**OXFORDSHIRE COUNTY COUNCIL’S RESPONSE TO CONSULTATION
ON THE FOLLOWING DEVELOPMENT PROPOSAL**

Application no: 22/03063/F

Proposal: Erection of 126 dwellings with access from Camp Road, provision of public open space and associated infrastructure

Location: Land East Of Larsen Road, Heyford Park

Engineering Plan

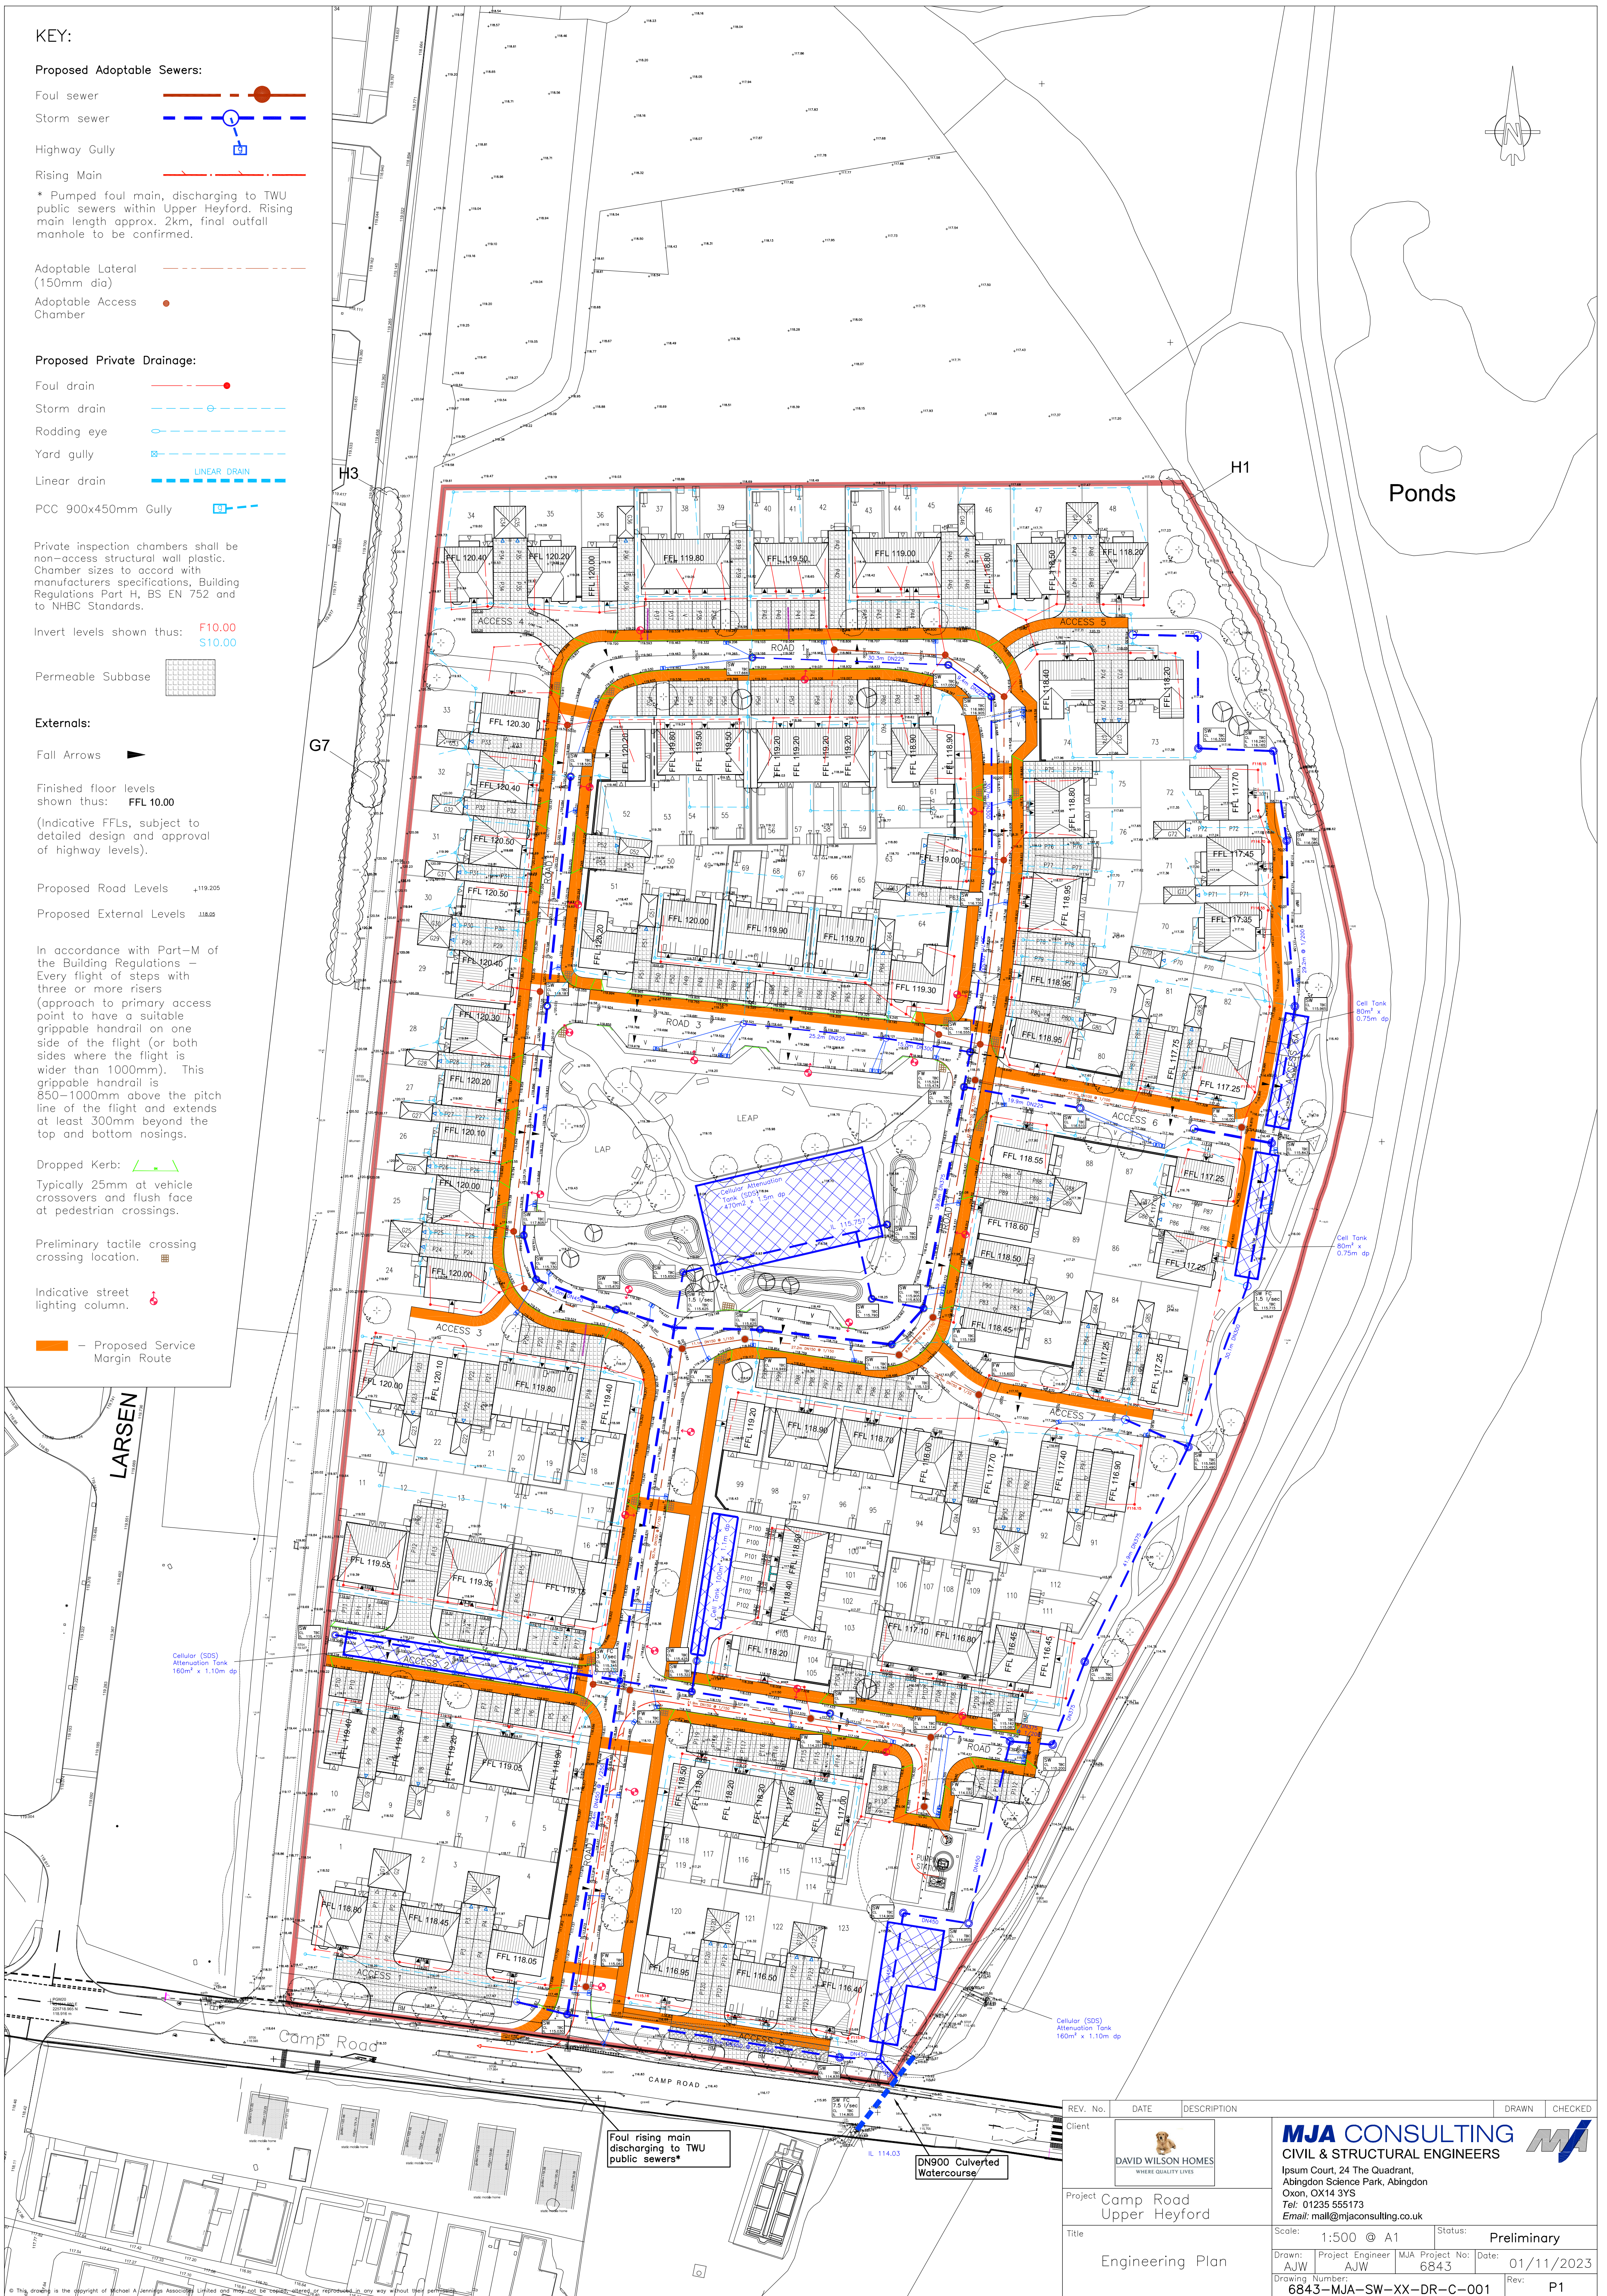
As part of a full application drawings are expected to be detailed. Provide invert and cover levels of all SuDS/drainage infrastructure. Include pipe gradients and pipe numbering which should read in line with the calculations.

Infiltration has been conducted mainly in the northern part of the site, infiltration should be conducted to cover the extent of the site. In areas where infiltration is feasible, infiltration techniques has not been used.

Provide surface water flood exceedance plan, demonstrating with flood arrows and proposed levels that all surface water will be kept away from structures and within the site boundary.
